July 7, 2011
Subject: **Portland Marine Terminal**
Federal Project No: DTMA1G10006/TIGER
State PIN: 017820.00
Amendment No. 3

Make the following changes to the Bid Documents:

PORTLAND INTERNATIONAL
MARINE TERMINAL IMPROVEMENTS
PORTLAND CUMBERLAND COUNTY
WALL SECTIONS

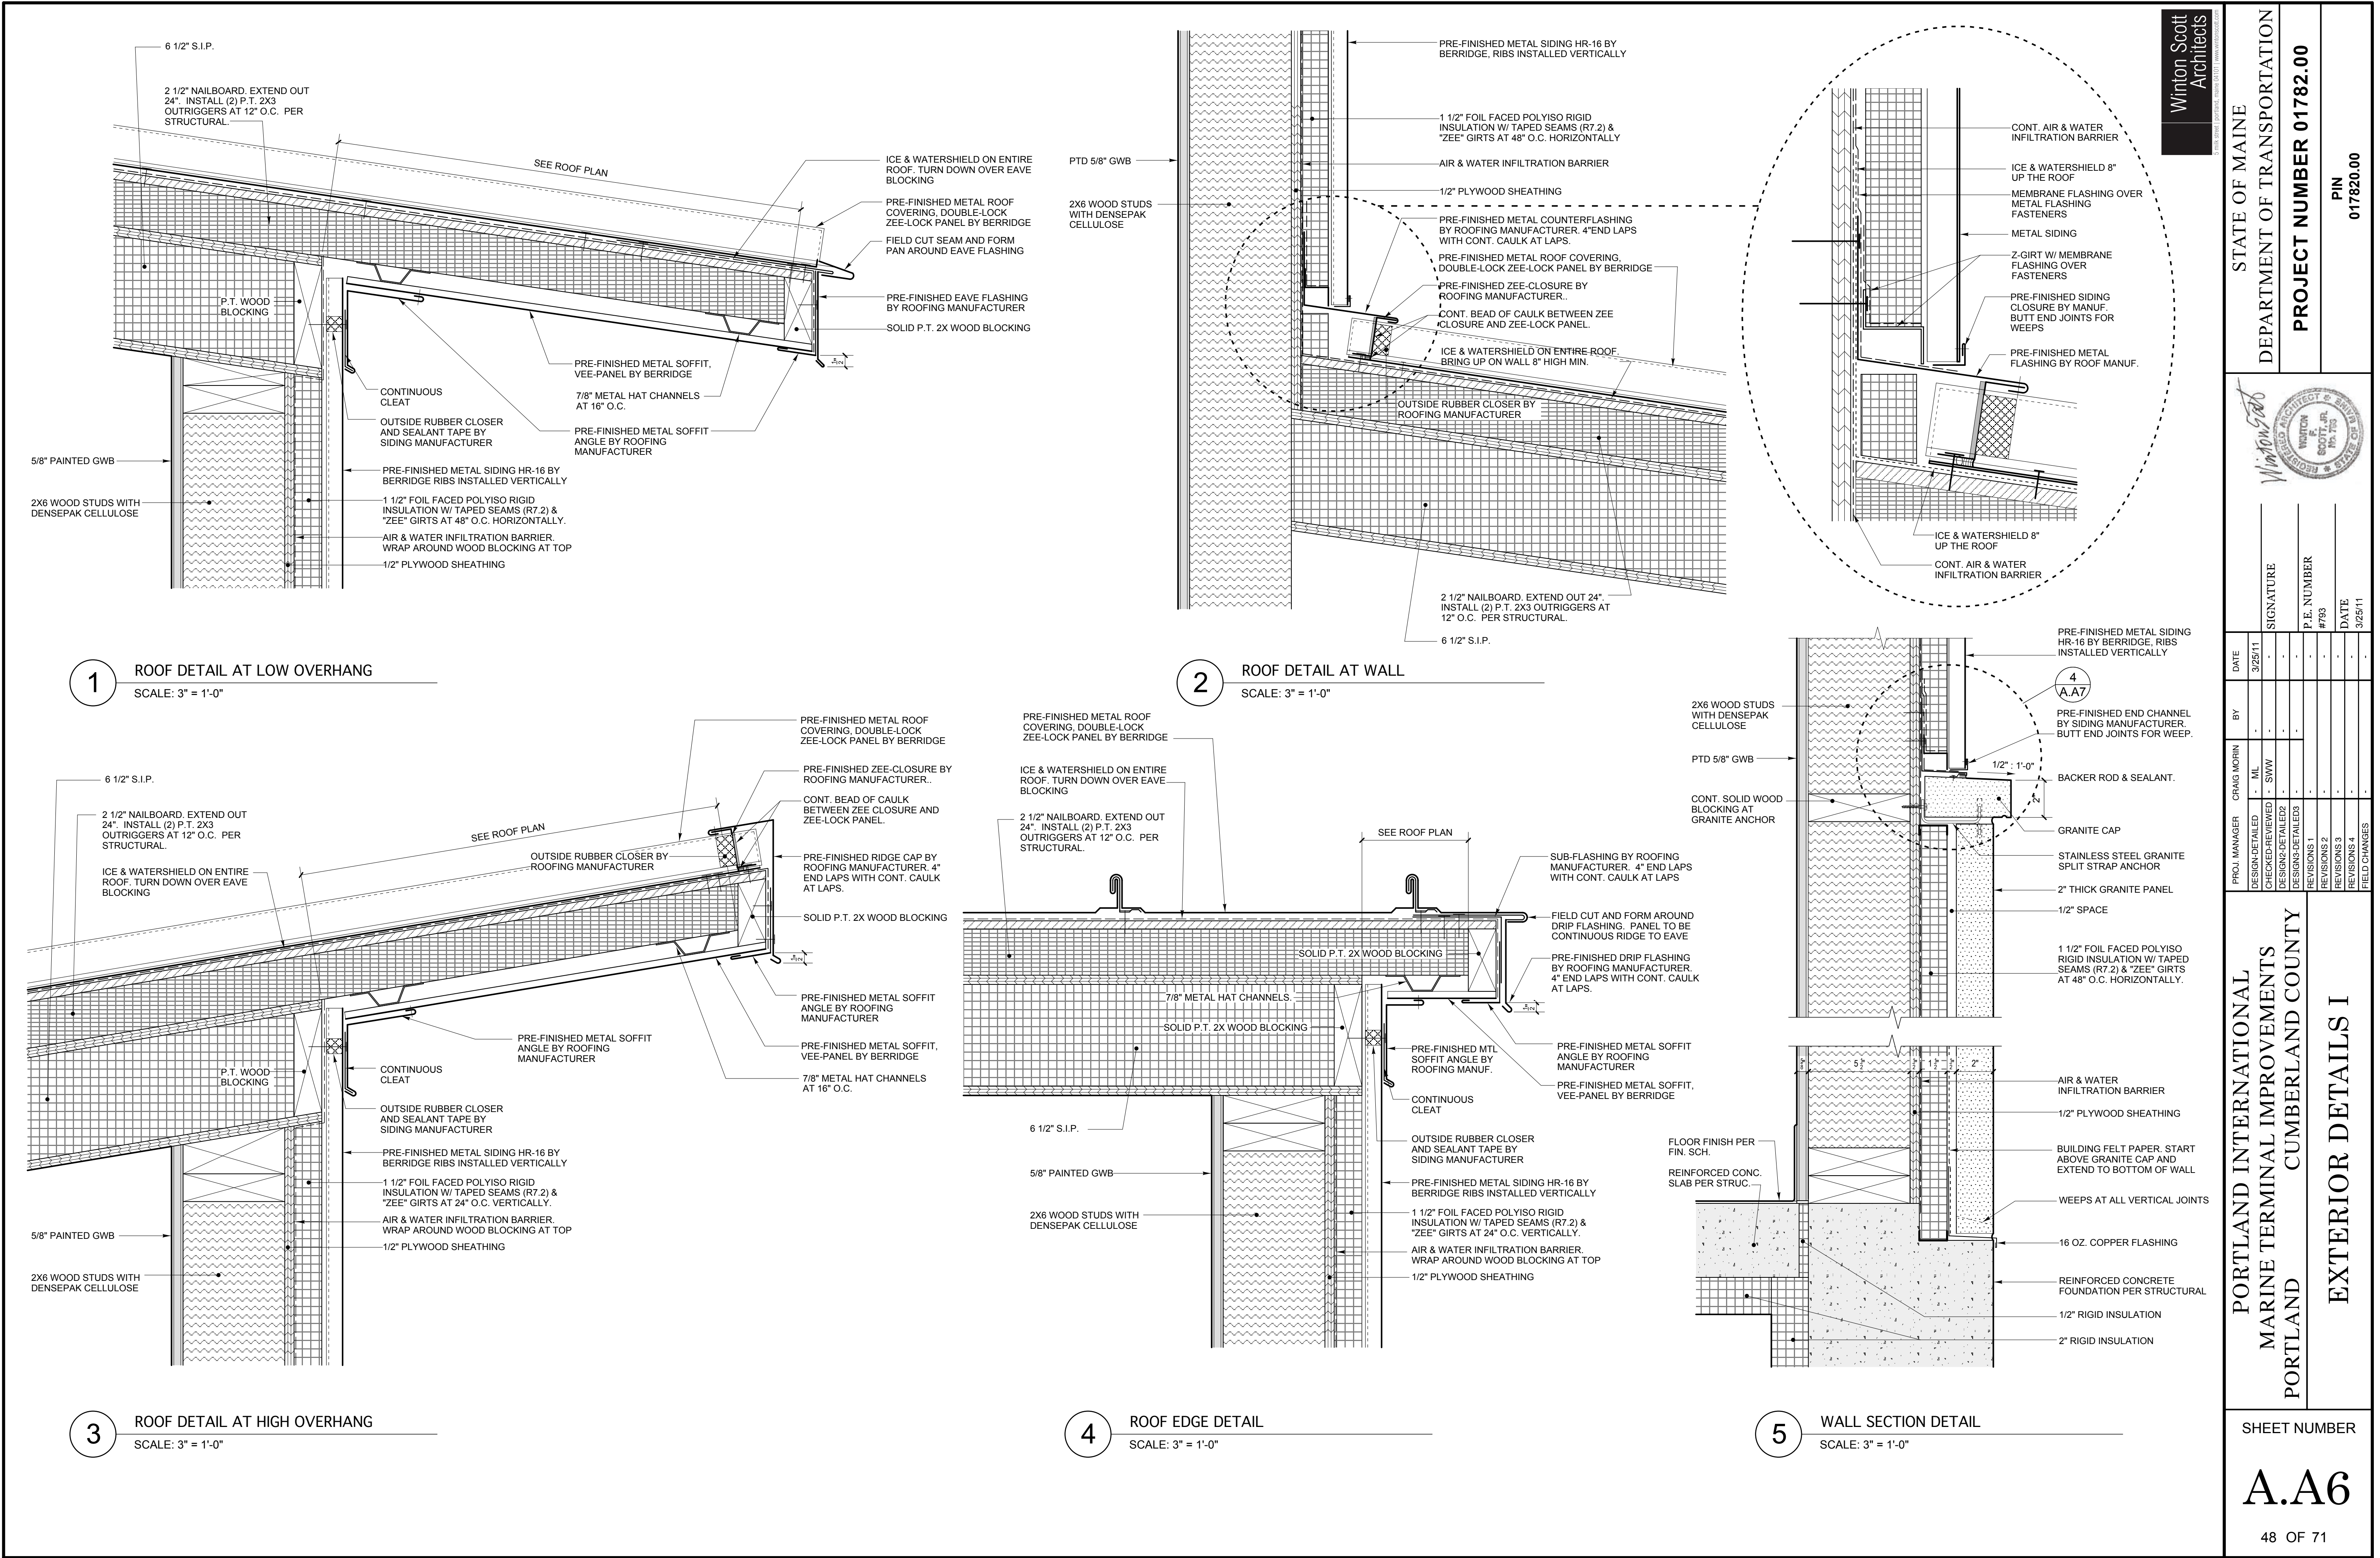
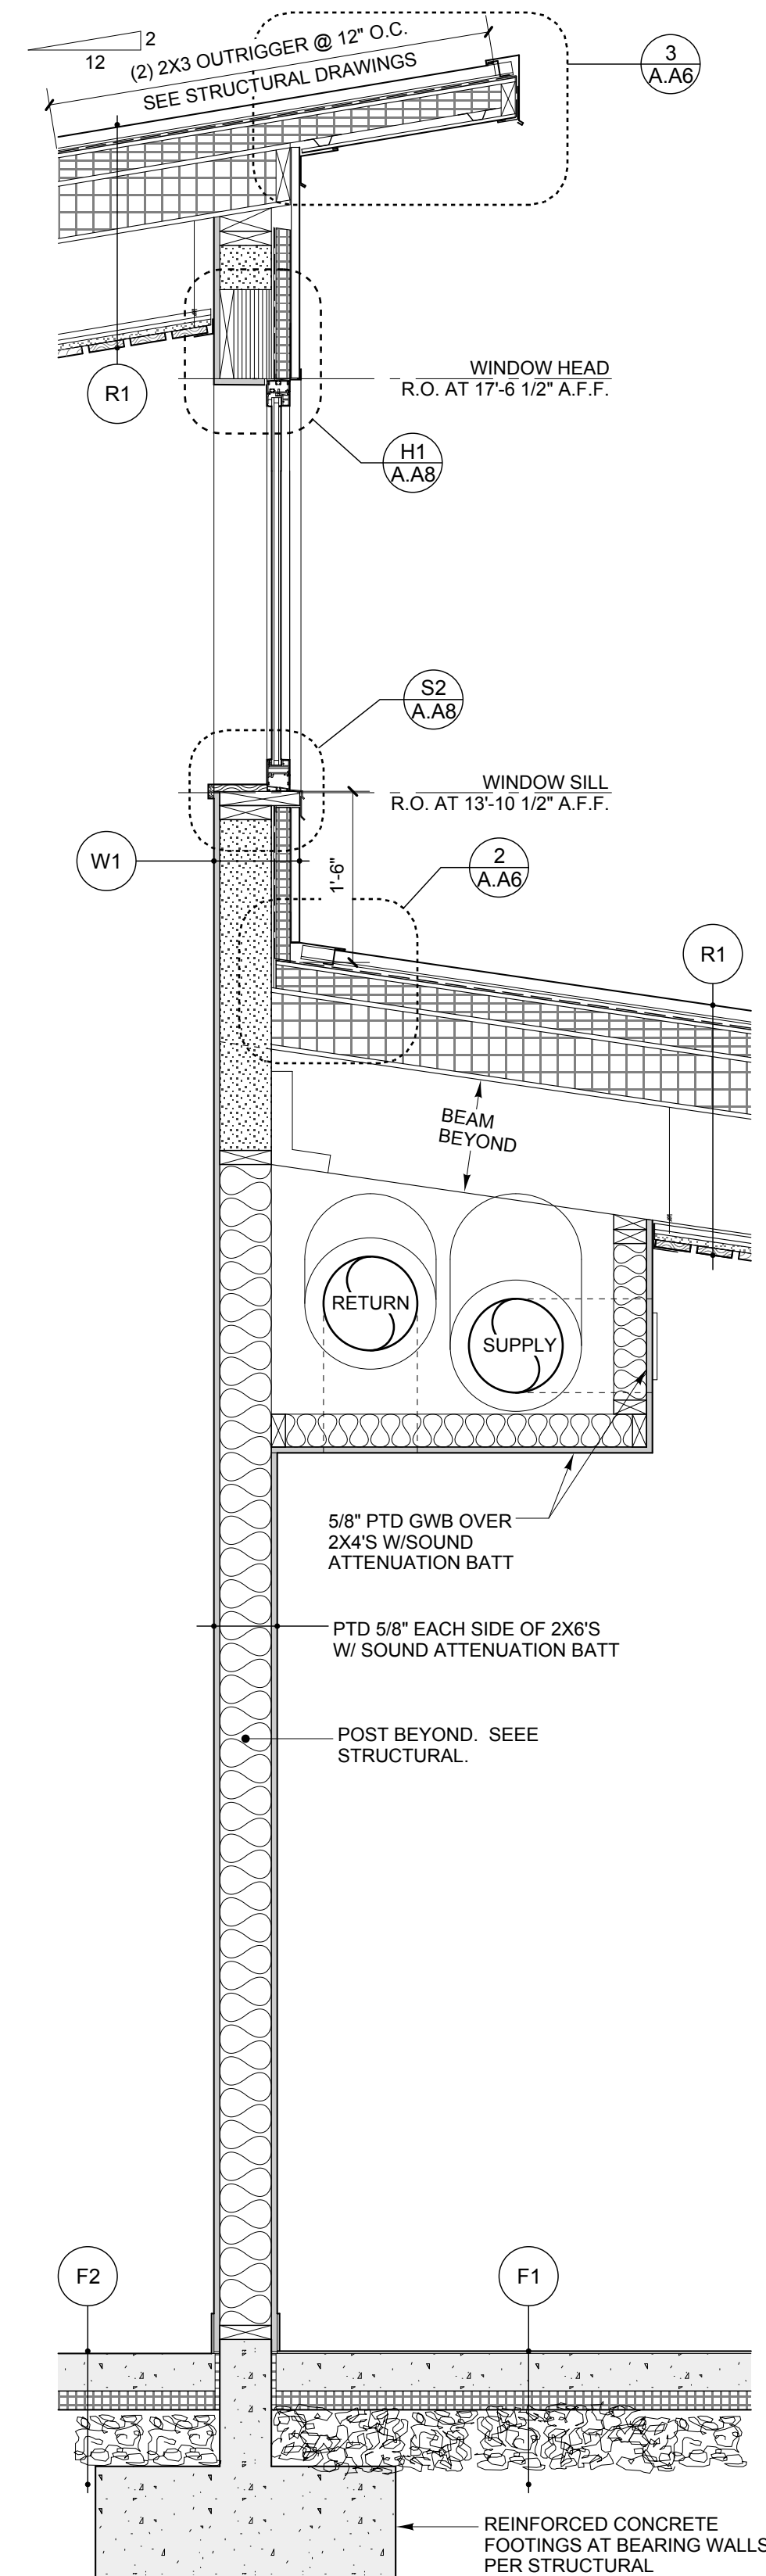
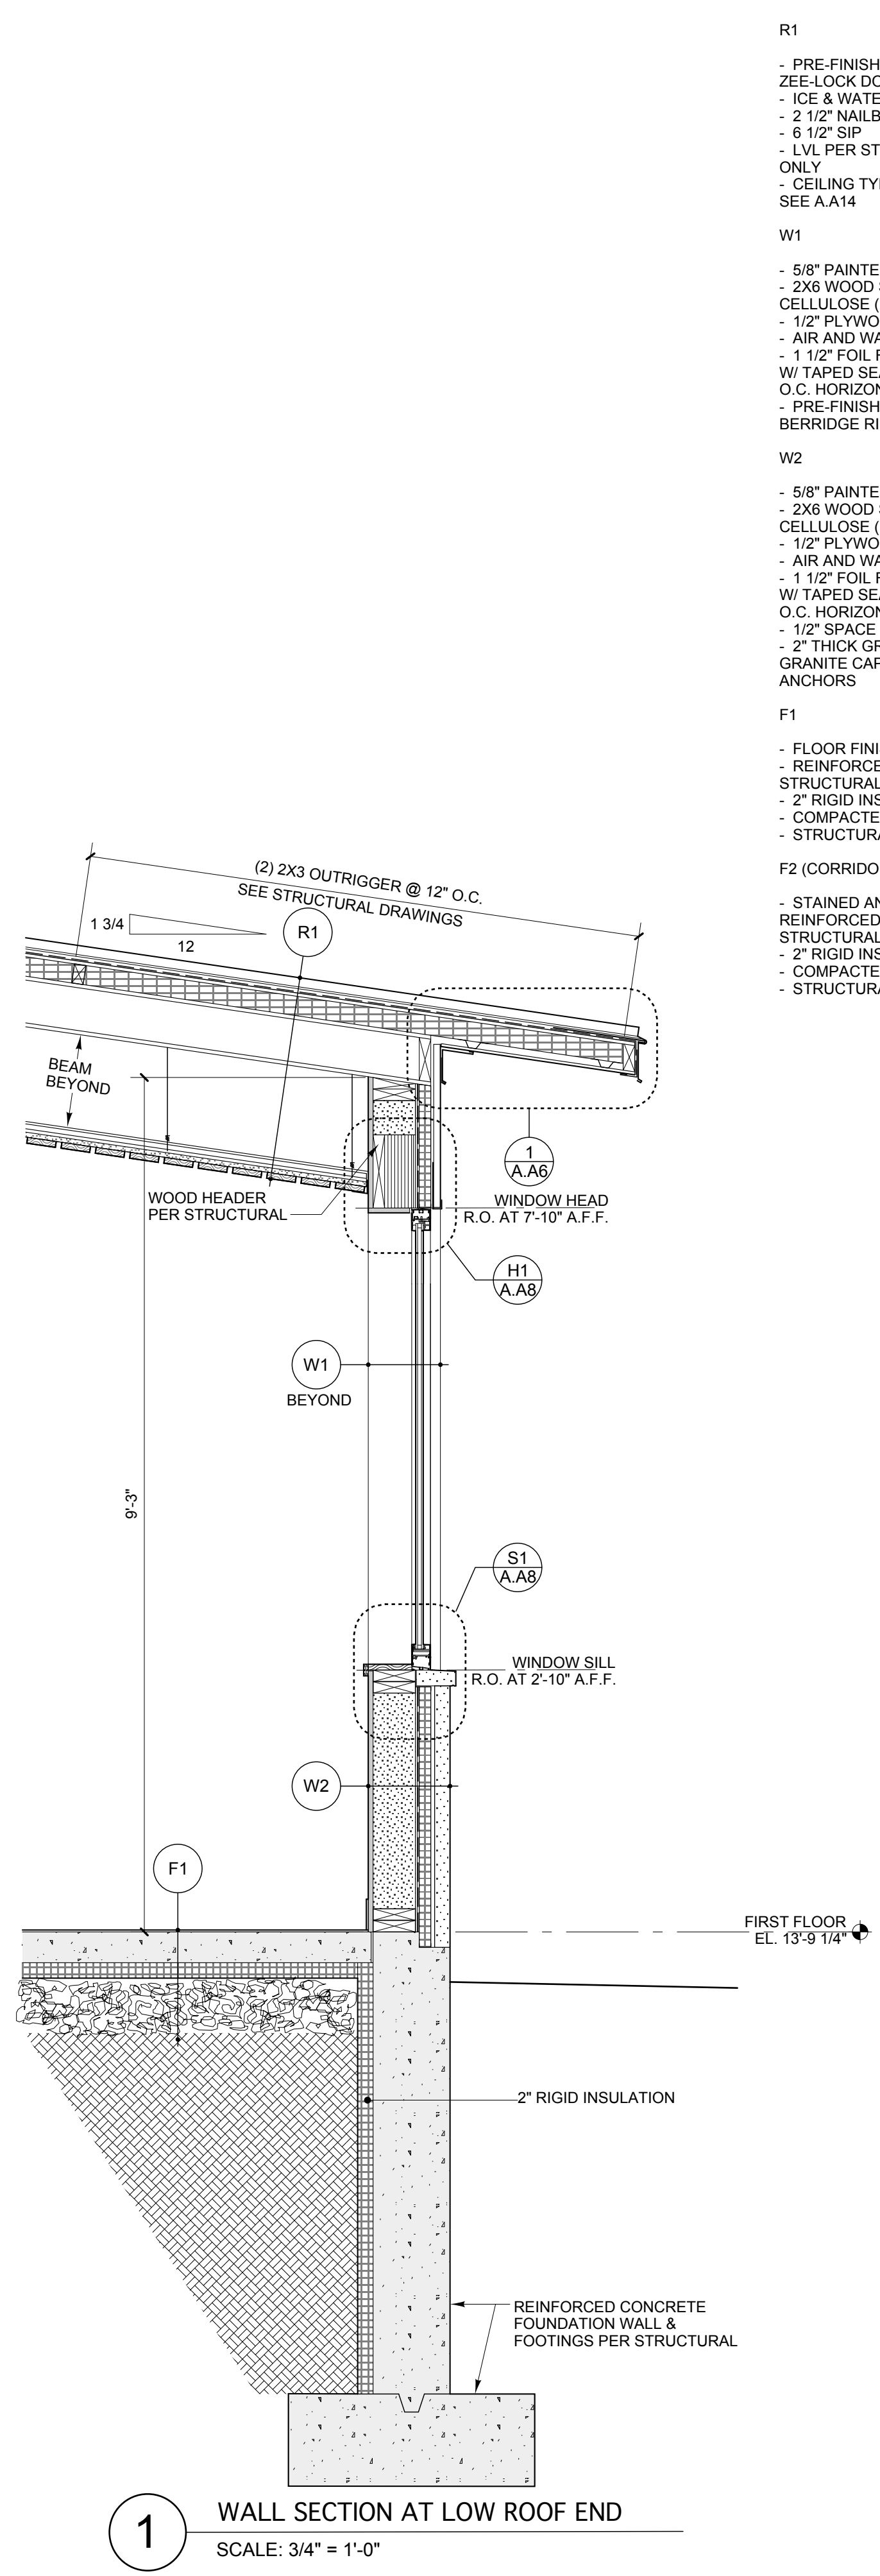
Question: Section 07 42 13 2.03 calls for #15 felt underlayment but the wall assembly W1 on A.A5 lists no such underlayment. Is it required? If so, where is it to be installed?

Question: Section 07 41 13 2.03 does not call out for high temperature ice and water shield under the metal roofing. Please advise.

Response: The wall assembly description "W1" on sheet A.A5 is correct. The #15 felt underlayment listed in Spec section 07 42 13, article 2.03 is not required.

Response: Specification Section 07 41 13, article 2.03 Underlayment Materials, the specified underlayment is revised to be "Grace Ultra" high temperature resistant roofing underlayment for use under metal roofs by W.R. Grace & Co. or approved equal.
